SSD 79240223  
JD6 (P&E)

**STATE SIGNIFICANT DEVELOPMENT APPLICATION 67175465**  
**APPLICANTS: CBUS PROPERTY, GALILEO GROUP, PLATFORM PROPERTY SERVICES**

I refer to the recent public exhibition of the application and thank the Department for the opportunity providing feedback to the proposed development of land at 378-and advise that following a review of the documents submitted, Council objects to the development proposal.

Drawing Title SECTION A

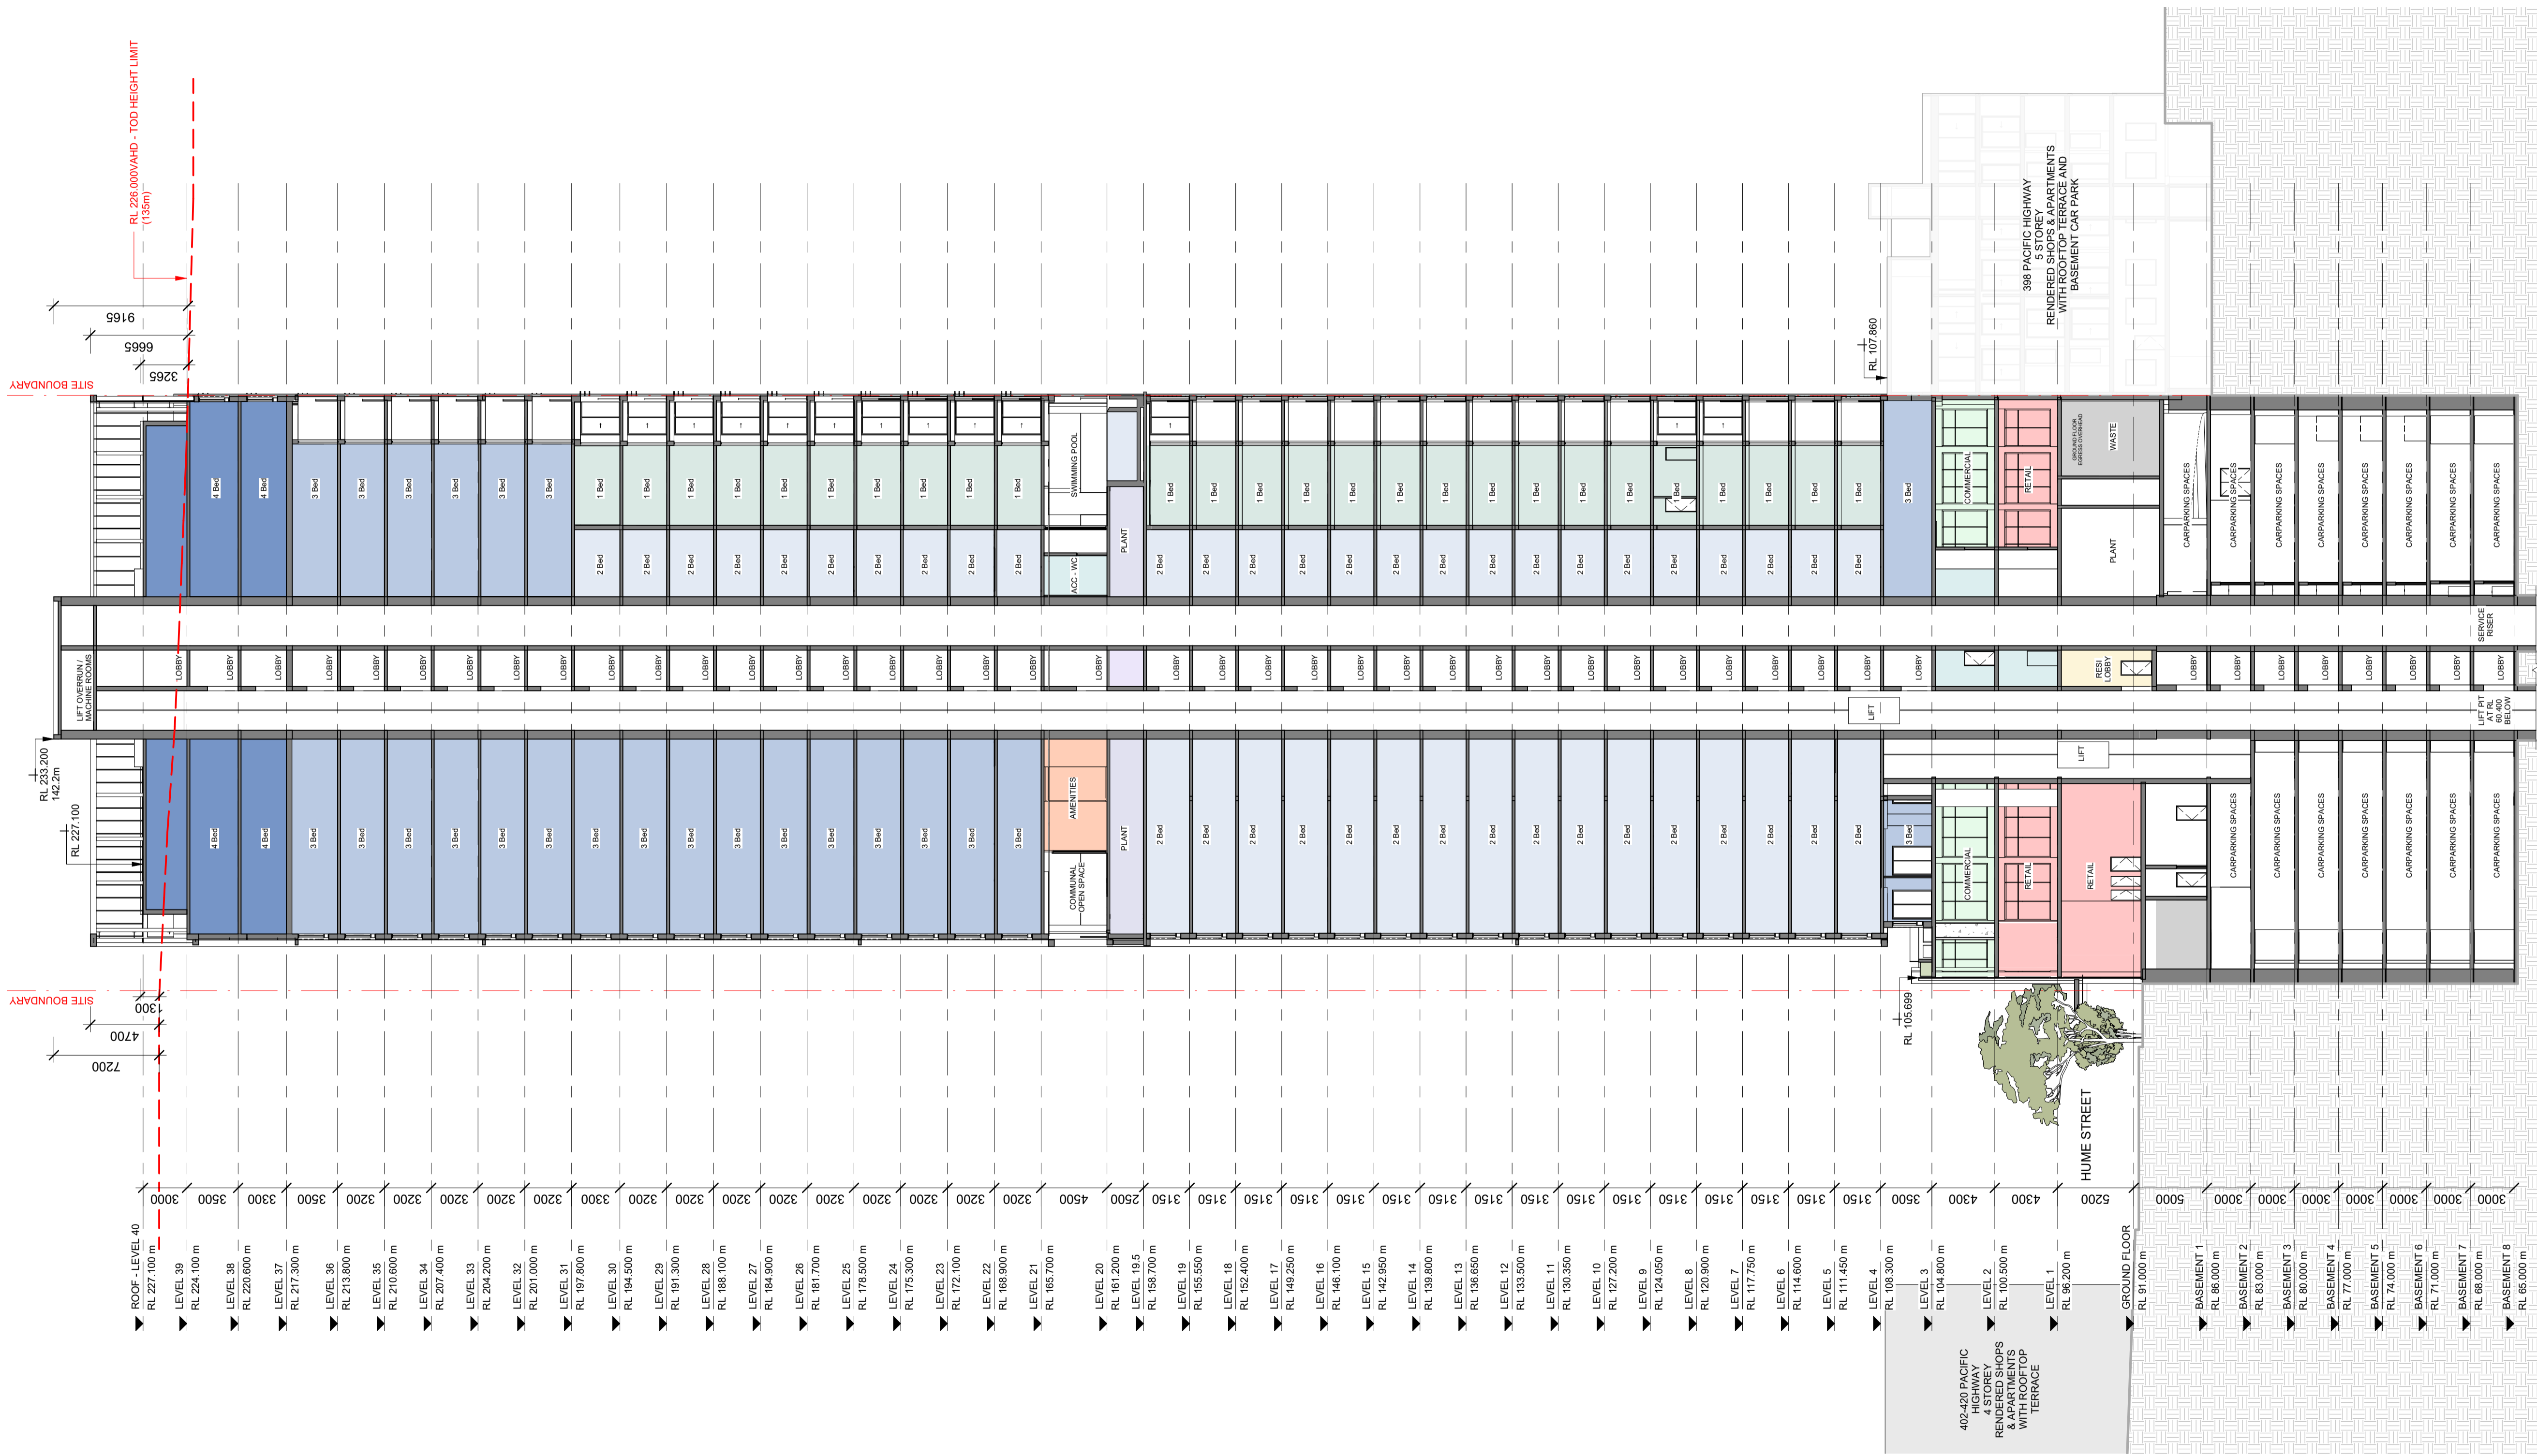
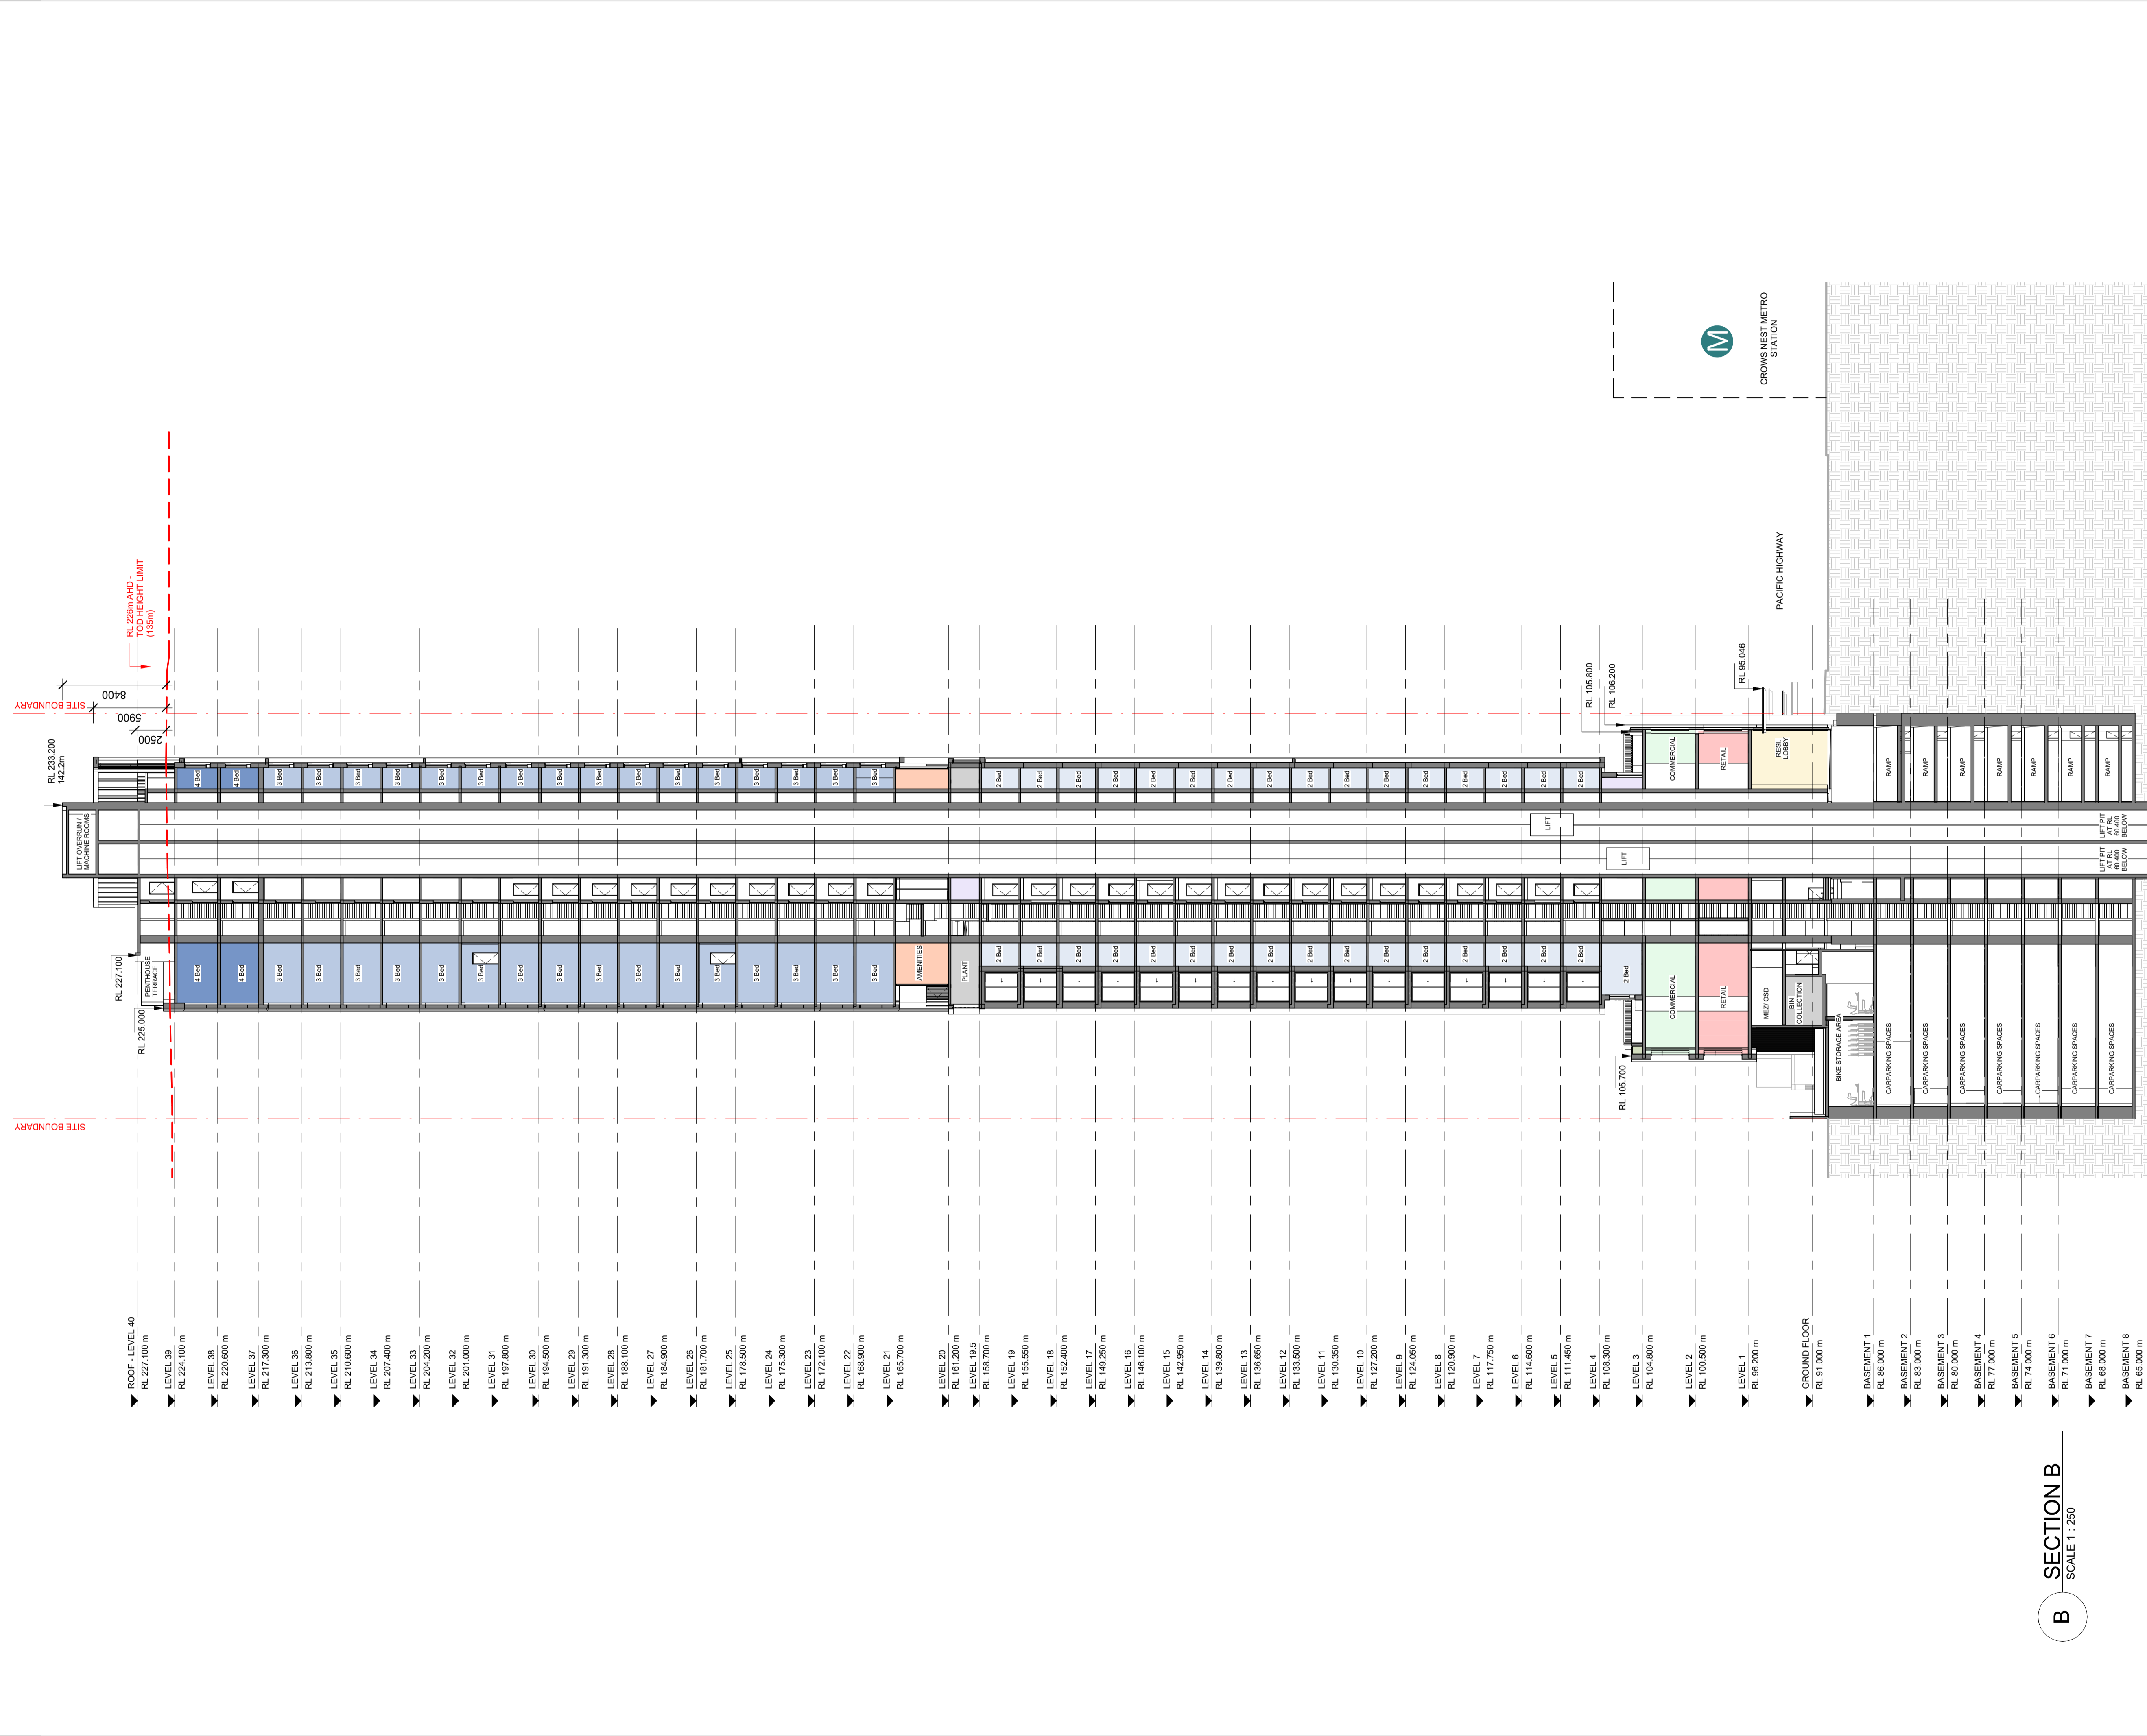
The proposal exceeds the 135m height of building permitted under the Crows Nest TOD framework by 7.2m (5.3%), resulting in a total building height of 142.2m. This exceedance is not supported.

The height of building control is to include all rooftop plant and building services, which should be fully contained within the maximum height limit. In this case, the breach is not solely attributable to rooftop services but is also primarily the result of generous floor-to-floor heights at the podium and upper levels, notably levels 21, 37 and 39.

The Design Guide requires a 4-storey podium fronting the Pacific Highway and Hume Street. The proposal includes a 3-storey podium with oversized floor-to-floor heights, intended to align with the datum of the neighbouring 4-storey podium to the north. While the design rationale is acknowledged, a compliant 4-storey podium with standard floor-to-floor heights could maintain this alignment while supporting delivery of the required non-residential floor space.

2. Reduce the overall building height to comply with the 135m maximum building height limit.
3. Apply floor-to-floor heights in line with the Design Guide.
4. Contain all rooftop plant and building services within the maximum height limit.
5. Provide equinox shadow analysis to detail impact on Crows Nest, including Willoughby Road, Ernest Place and Hume Street Park, having regard to clause 7.4 Design excellence subclauses (3)(d)(vi) and (3)(d)(ix).

8. Provide a 4-storey podium in accordance with Design Guide, street wall height provision and maximise the commercial potential and capacity of the development, given its prime location for this purpose.
9. At least meet the minimum 1.5:1 non-residential FSR should be provided and increasing the ratio to 2.0:1 be considered, to support the employment and activation objectives of the precinct.
10. Should these aspects of the development not be amended to at least comply with the development standard, the application is unable to be approved, in accordance with clause 4.6 of the North Sydney LEP.
11. An amendment of the LEP to include the minimum non-residential floor space ratio in the TOD precinct in clause 4.6 (8) of the North Sydney LEP 2013 should be considered, urgently.
